OXFORDSHIRE COUNTY COUNCIL'S RESPONSE TO CONSULTATION ON THE FOLLOWING DEVELOPMENT PROPOSAL

Application no: 23/01493/REM

Proposal: Reserved Matters Application including access, layout, landscaping and scale pursuant to outline planning permission 14/02121/OUT for internal primary and secondary streets along with the partial discharge of conditions 12 (Building for Life 12), 16 (means of vehicular access), 17 (means of pedestrian/cycle links) and 19 (detailed surface water drainage scheme) for Phase 1B

Location: Proposed Himley Village North West Bicester, Middleton Stoney Road, Bicester

TITLE  
PHASE 1B  
BUS SWEPT PATH ANALYSIS  
SHEET 1

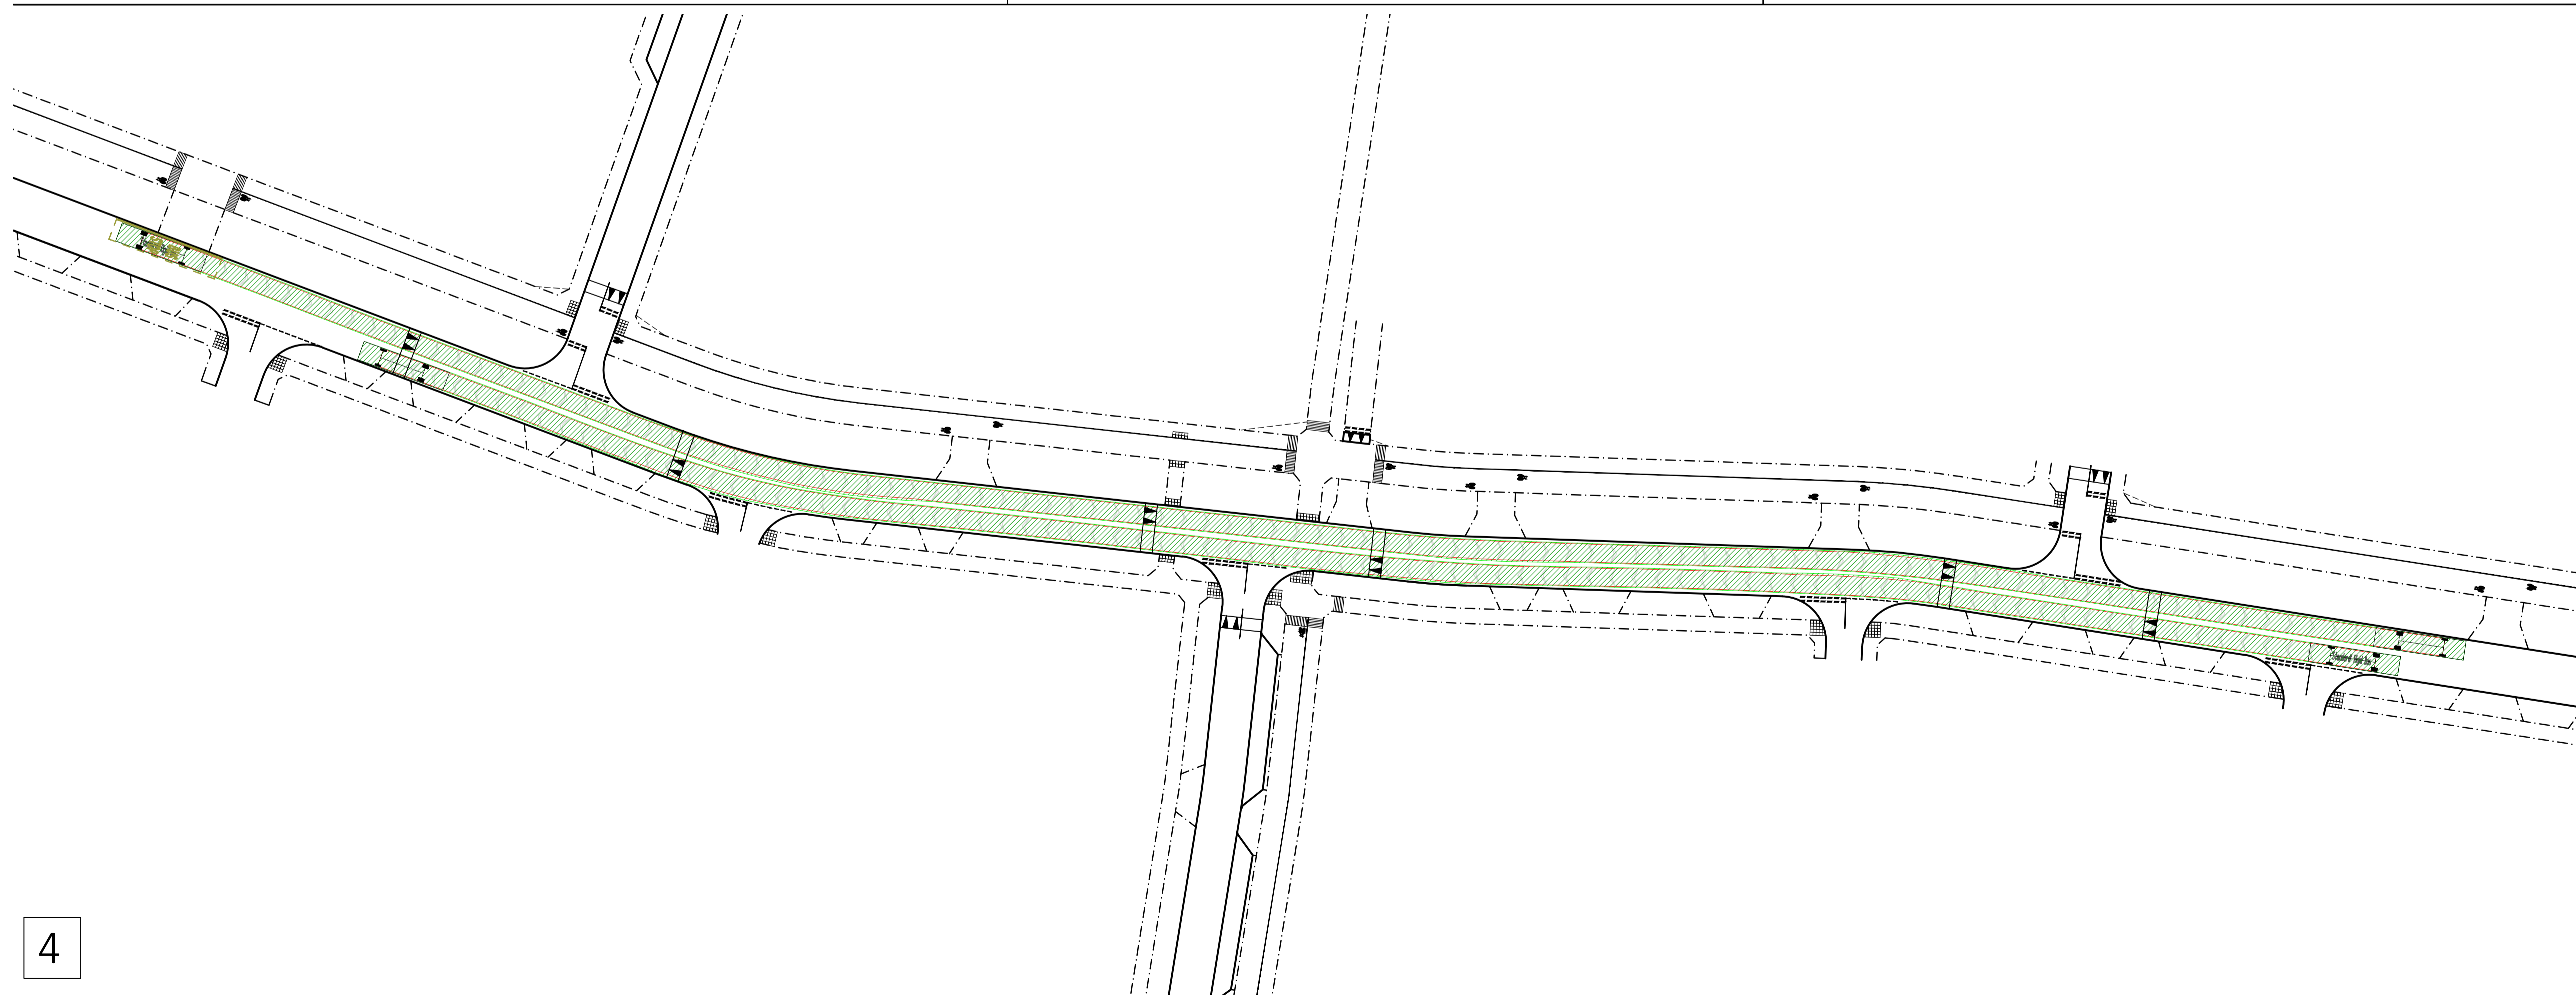
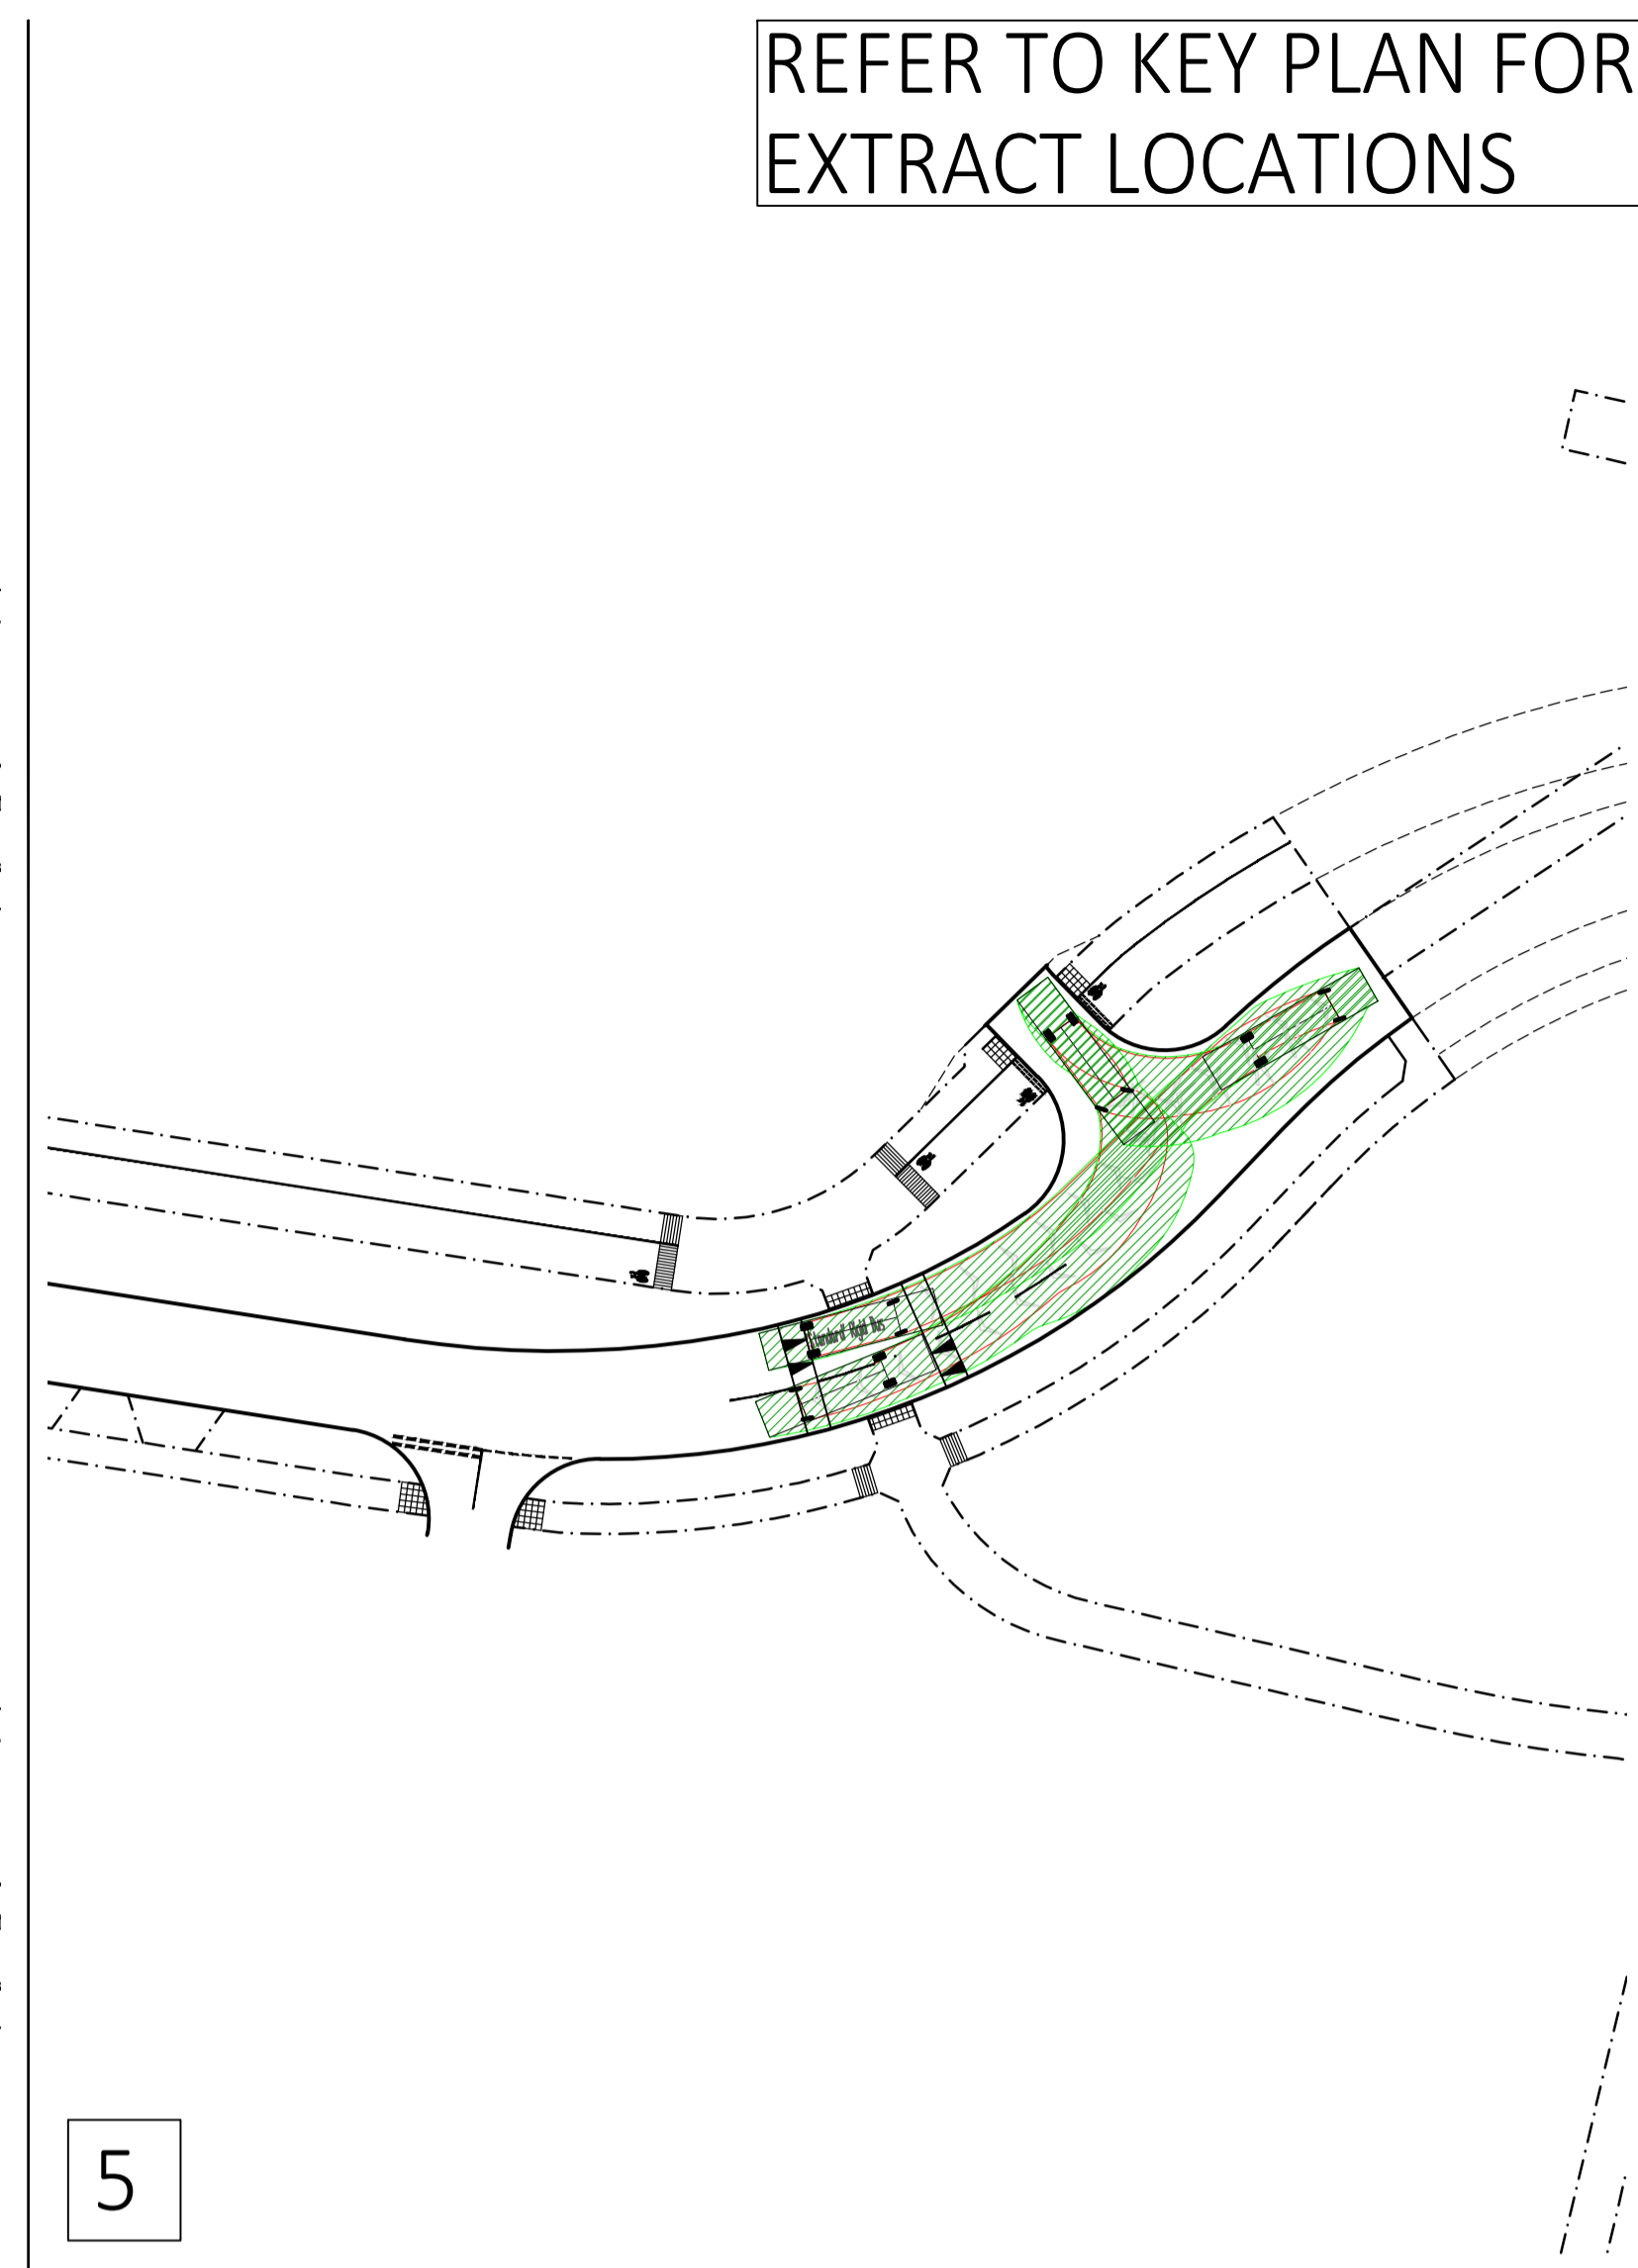
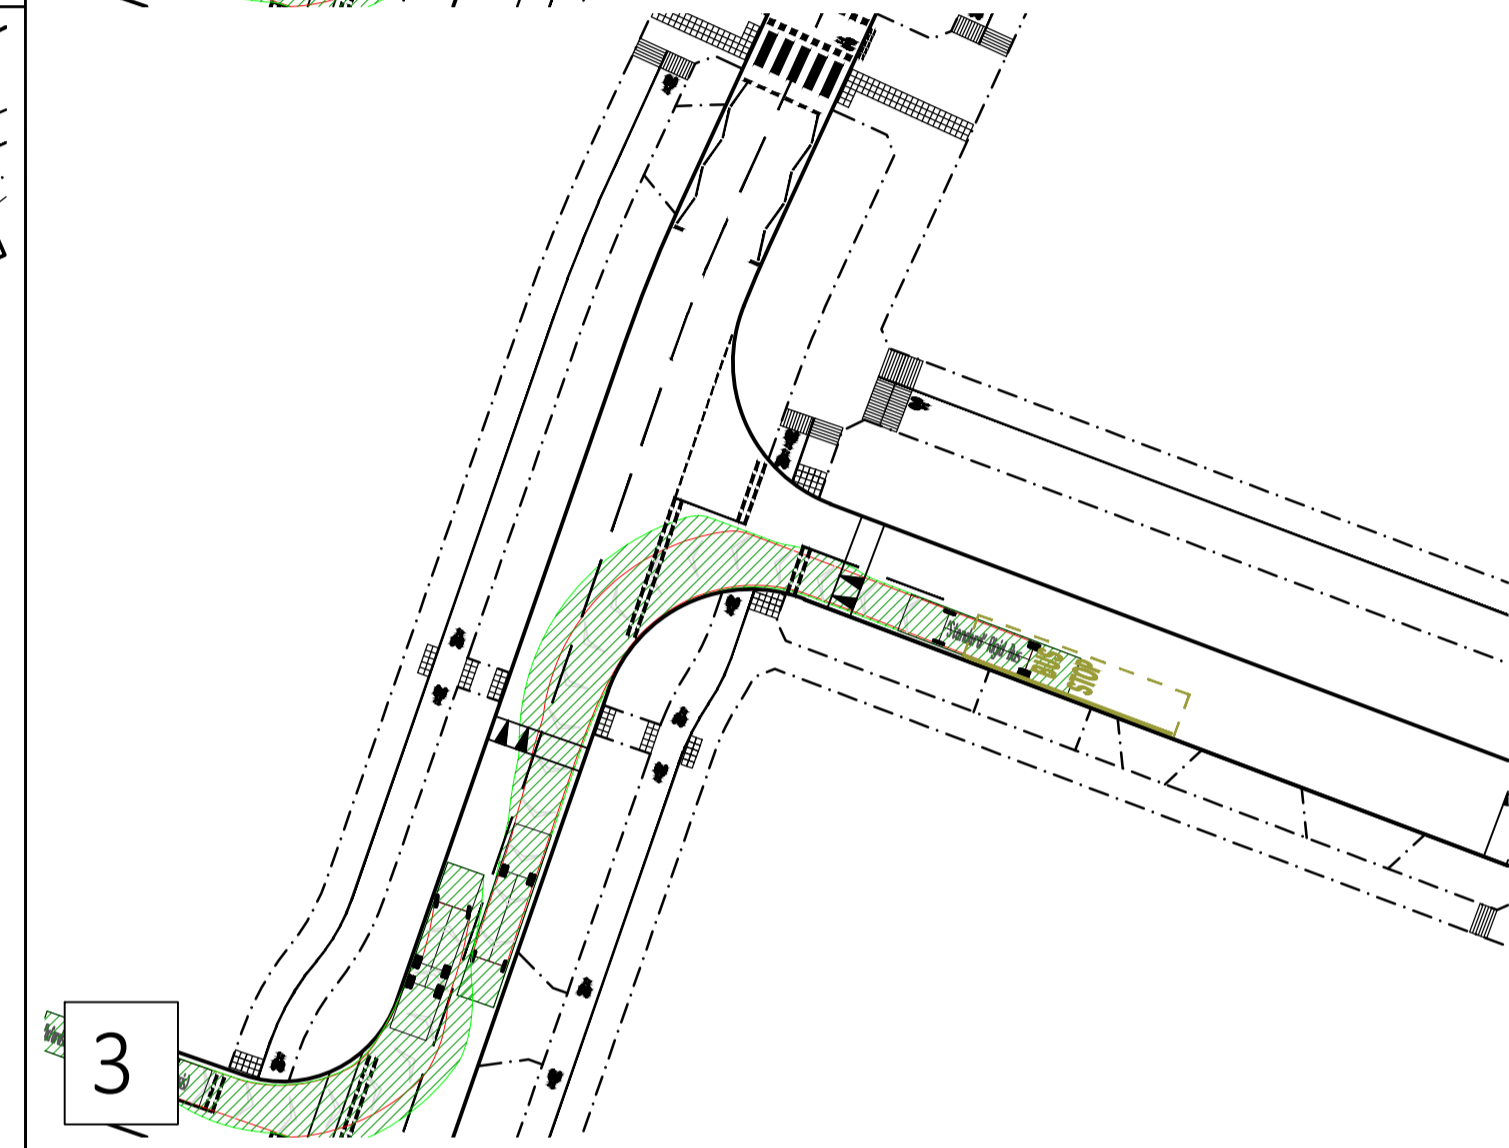
I previously explained that the temporary bus turning heads were not acceptable as it would require buses reversing over the raised cycle crossings. After discussions with the applicant, it has been agreed that the raised cycle crossings at the northern end of the Spine Road North - South and at the eastern end of the Spine Road East - West will be implemented when Oxfordshire County Council have confirmed that the requirement for the use of the temporary bus turning heads has ceased.

In addition, the raised crossings at the western end of the strategic secondary streets will be implemented when these roads connect to Phase 3 and Oxfordshire County Council have confirmed that the temporary turning heads are no longer required. Insets on the Engineering Layout Sheets 1 to 4 include the layout of all the temporary turning head as well as the agreed final layout.

In accordance with the approved Phase 1B Engineering Layout Sheets 1 to 4 (dwg nos 27141-HYD-1B-XX-DR-C-2200/P09, 27141-HYD-1B-XX-DR-C-2201/P10, 27141-HYD-1B-XX-DR-C-2202/P10, 27141-HYD-1B-XX-DR-C-2203/P09) works associated with the temporary bus turning heads shall be constructed and remain in place until Oxfordshire County Council have confirmed that the temporary turning heads are no longer required. The final road layout as shown on the approved plans, including raised tables and all road markings, shall be completed within 6 months of the final use of the temporary turning heads unless otherwise agreed in writing with the Local Planning Authority.
